Application No: A/193/20/PL
Site Address: Ham Manor Cottage Ham Manor Way Angmering BN16 4JQ
Description of works: Erection of a 1 No. 3 bedroom chalet bungalow & detached garage. This site is in CiL Zone 3 and is CIL Liable as dwelling.

Thank you for your internet representation made on 14th February 2021 which has been recorded as an objection with the comments as follows:

Planning application 193/20/PL

Proposed Street Scene (Scale 1:200)

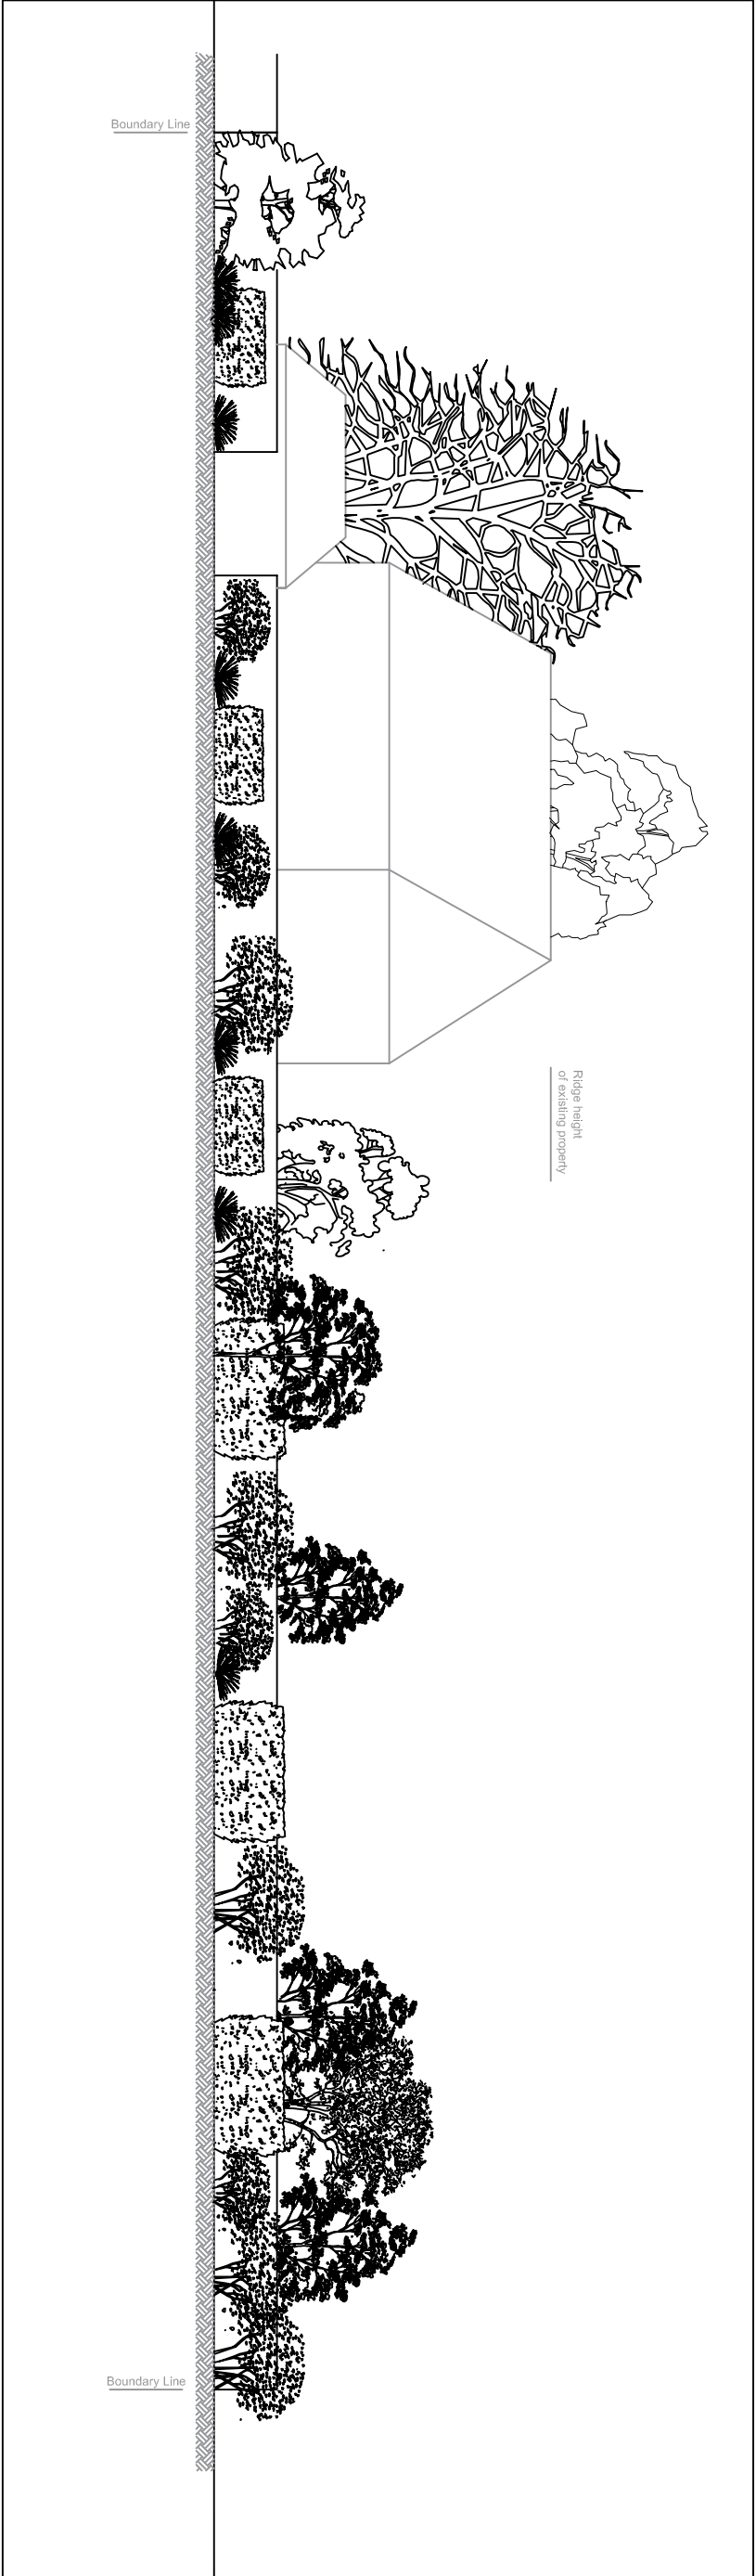
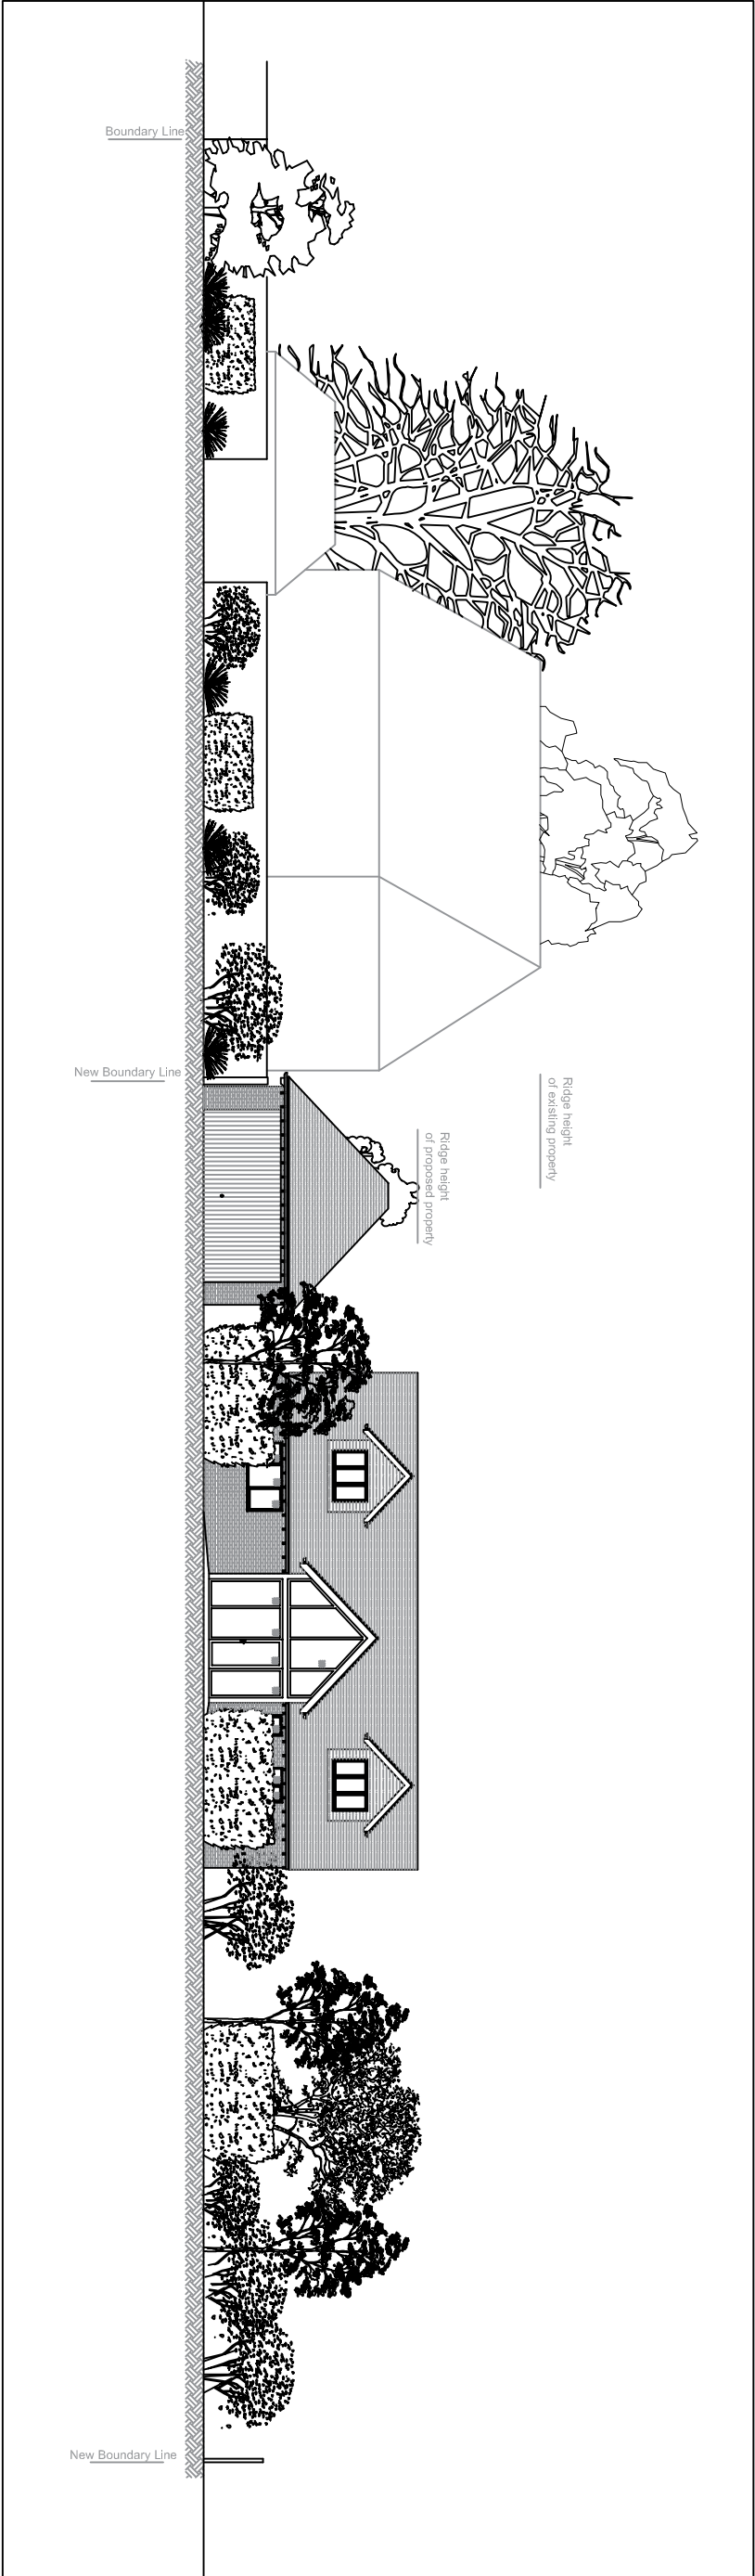
- Inadequate plot size for proposed property which is not in keeping with the setting or sympathetic to the street scene (conflicts with design & compliance of the Neighbourhood Plan 4.7 & 6.8)
- At odds with the generally well planned & spaciousness of Ham Manor Estate resulting in a detriment to the character of the area. (conflicts with design & compliance of Policy SP1 of the Local Plan)
- Proposal in breach of established building line of other properties adjoining Ham Manor Way (conflicts with design & compliance of Policy SP1 of the Local Plan) See attached PDF indicating building line in blue on north side of Ham Manor Way.
- Biodiversity gain ignored - considerable loss of vegetation due to significant access proposals with negative biodiversity impact. Large tree plus vegetation removed just before planning application made. See attached

- Adverse impact of building form on the amenity of existing buildings & landscape setting (conflicts with design & compliance of Policy SP1 of the Local Plan)
- Applicants Planning Statement misleading in some areas - item 6.5 A/55/19/PL quoted as precedent when actually A/55 benefited from an extant approval - item 6.13 quoted inline with neighbouring dwellings when actually indicated in front of building line- 6.15 leaves properties with good sized plots when this is not the case.

All of the above are reasons why this application should not be approved. Screenshot 2021-02-11 at 23.40.40. Ham Manor Way Historic Build line/ Street scene.pdf
